DOC20/905735

2 November 2020

**St Marys Intermodal – Modification 1 –
Rail Siding Refurbishment Works Package (SSD 7308 Mod 1)
Advice on Modification**

Figure 9 | Rail refurbishment works engineering drawings – Sheet 05 of 05 (Source: Applicant's Modification Report)

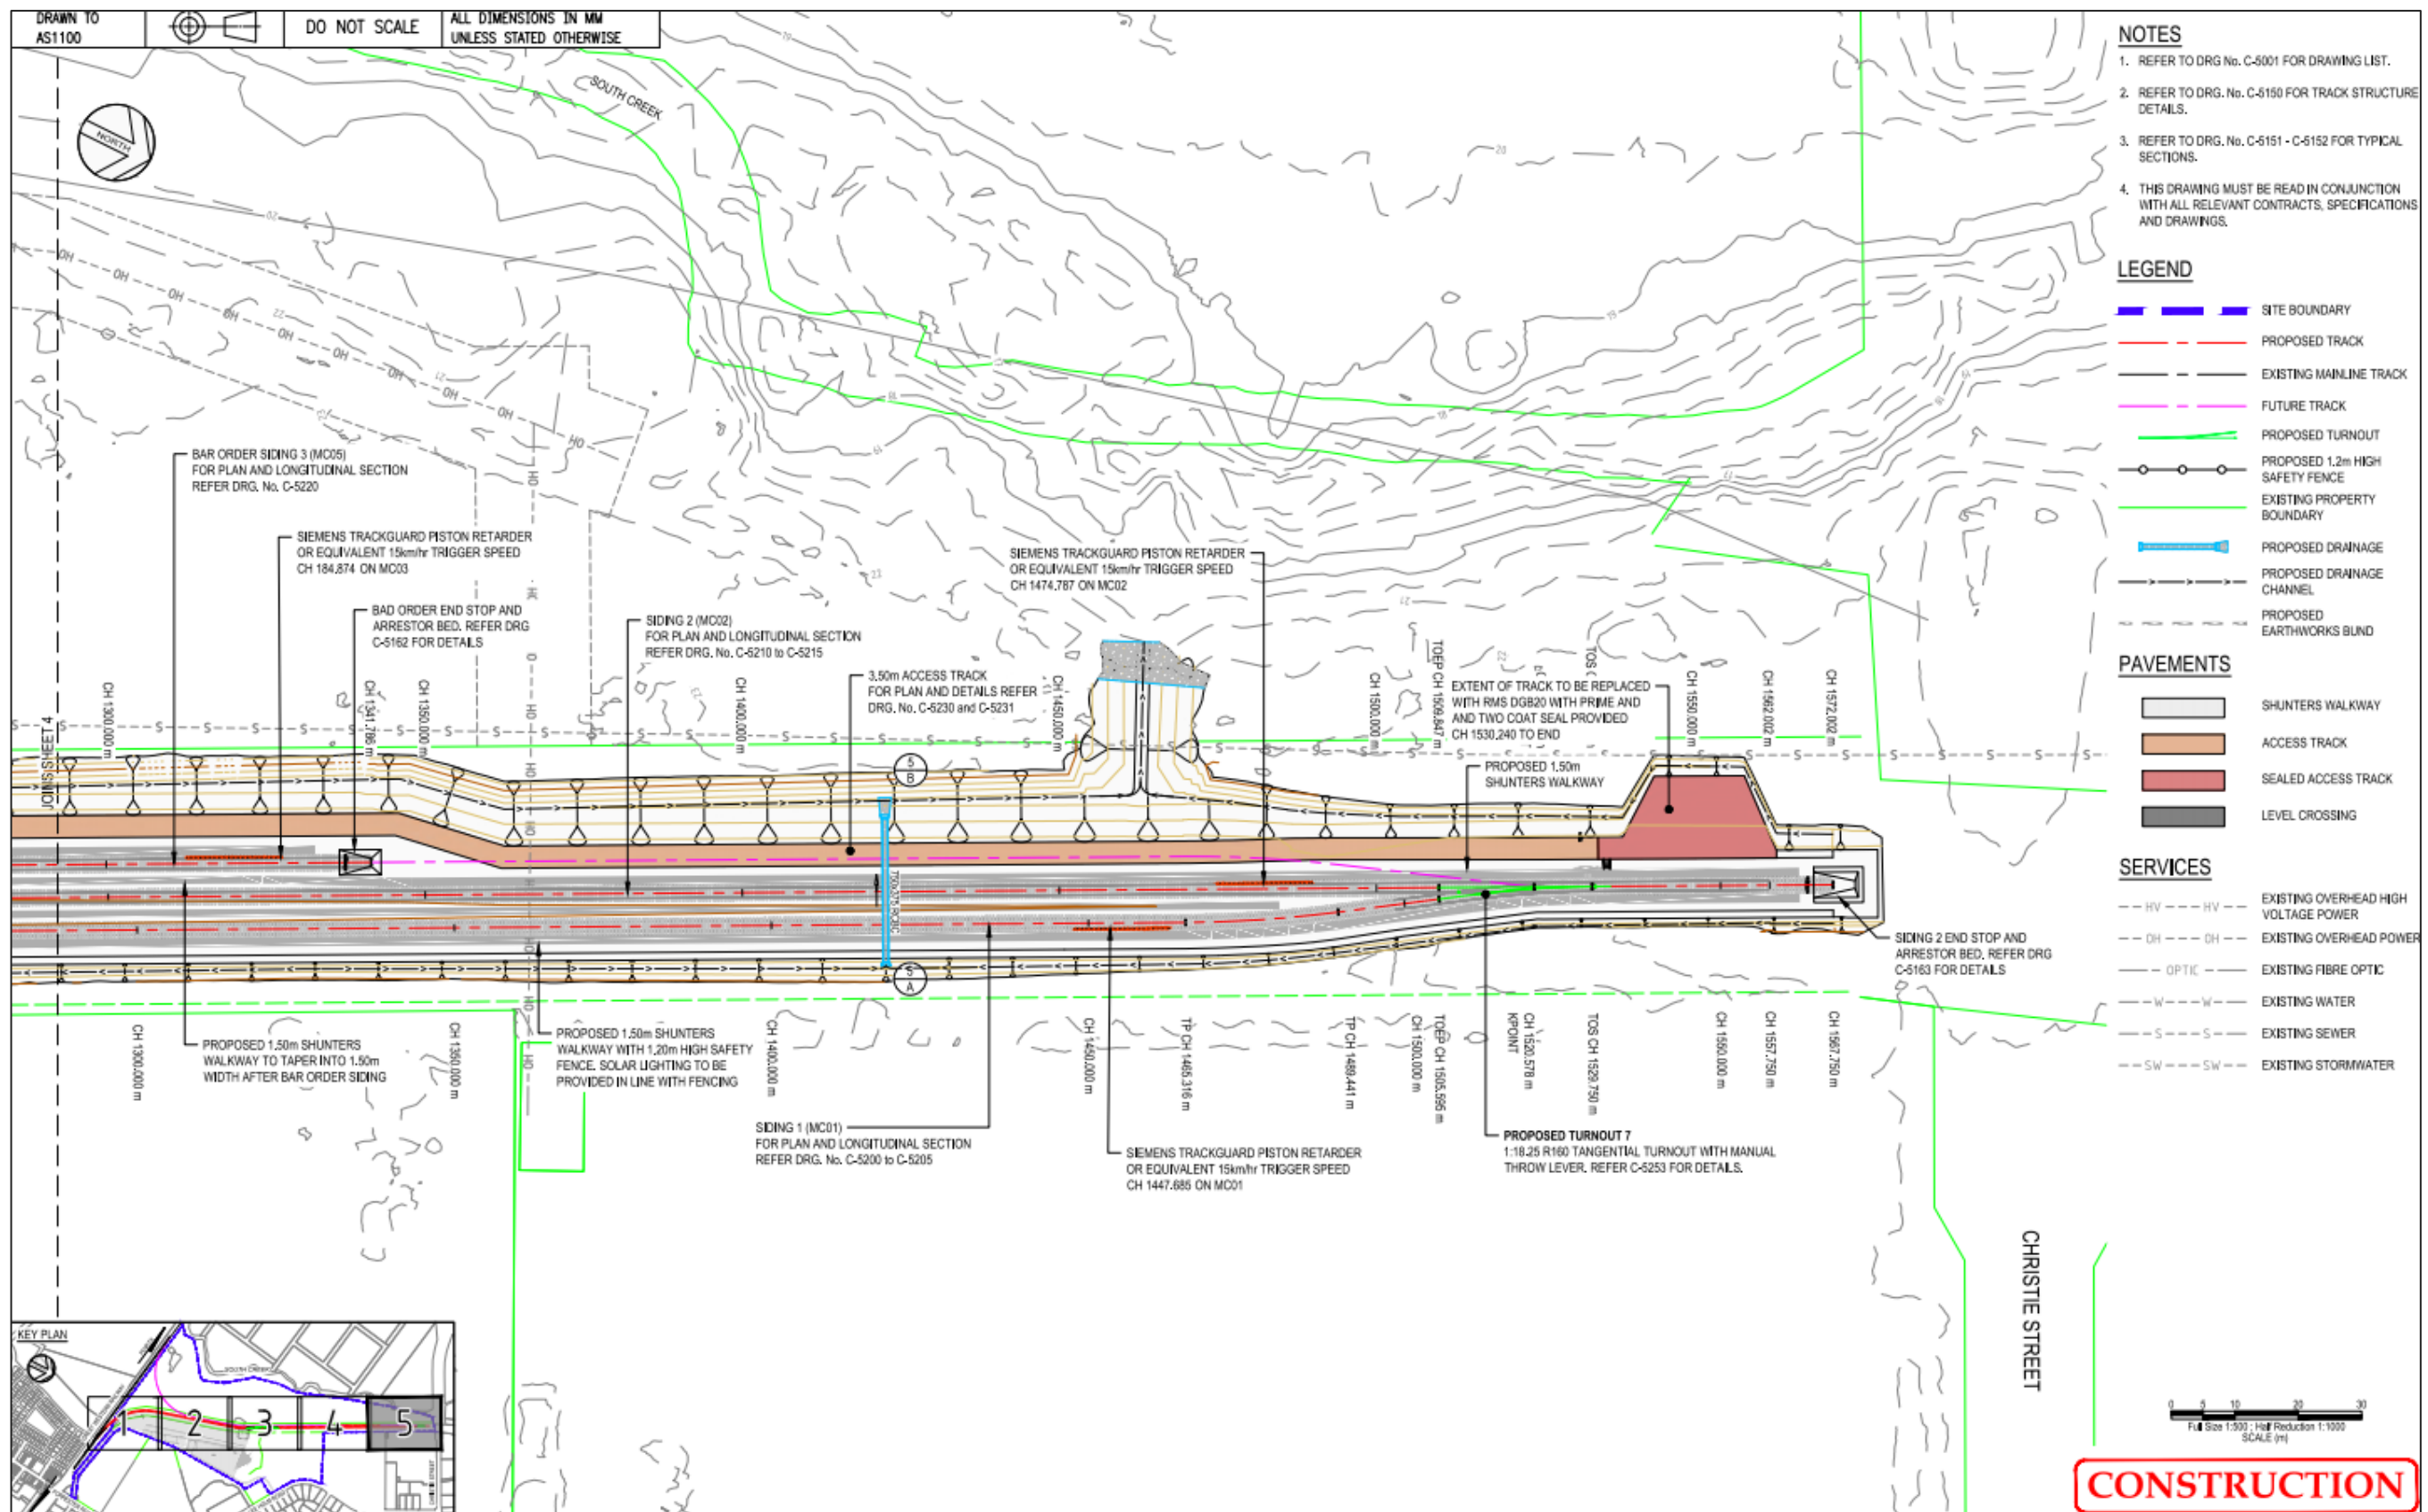
It appears that in the updated NIA, the section of the rail siding which extends north of the area considered in the EIS has been assessed using the provisions from the *Rail Infrastructure Noise Guideline* (EPA, 2013) (RING) for non-network rail lines.

However, it appears that siding will be used for shunting, switching and storage of trains as part of the intermodal facility and does not lead to other industrial premises. As such the EPA considers that the siding sections north of the intermodal are part of the industrial premises and should be assessed using the *Noise Policy for Industry* (EPA, 2017) (NPfI)

Appendix 3 of the RING states: *“Where a non-network rail line exclusively servicing one or more industrial sites extends beyond the boundary of the industrial premises, noise from this section of track should be assessed against the recommended acceptable LAeq noise levels from industrial noise sources for the relevant receiver type and indicative noise amenity area...”*

This was developed for situations where rail activities between the development site and the connection to a network line would be a discrete activity. In this instance, as described above, the sections of rail sidings north of the intermodal is not considered a discrete activity, but rather part of the industrial activities at the intermodal. Therefore, activities that occur on this section of the siding such as shunting, switching or storage should be considered part of the industrial activity at the premises and assessed using the NPfl in conjunction with all other operational noise sources.

The EPA recommends that sections of the siding north of the intermodal should be assessed in accordance with the *Noise Policy for Industry* (EPA, 2017) in conjunction with all other operational activities on the premises.

The original EIS noise impact assessment did not assess rail refurbishment of the whole length of the siding which is proposed to be refurbished in this modification. As such, the construction impacts presented in the modification documents do not appear to consider potential impacts generated by rail refurbishment in the areas proposed in this modification.

The EPA recommends that construction noise and vibration impacts generated by this proposal – that were not considered in the original EIS or other modifications – be assessed as part of this modification.
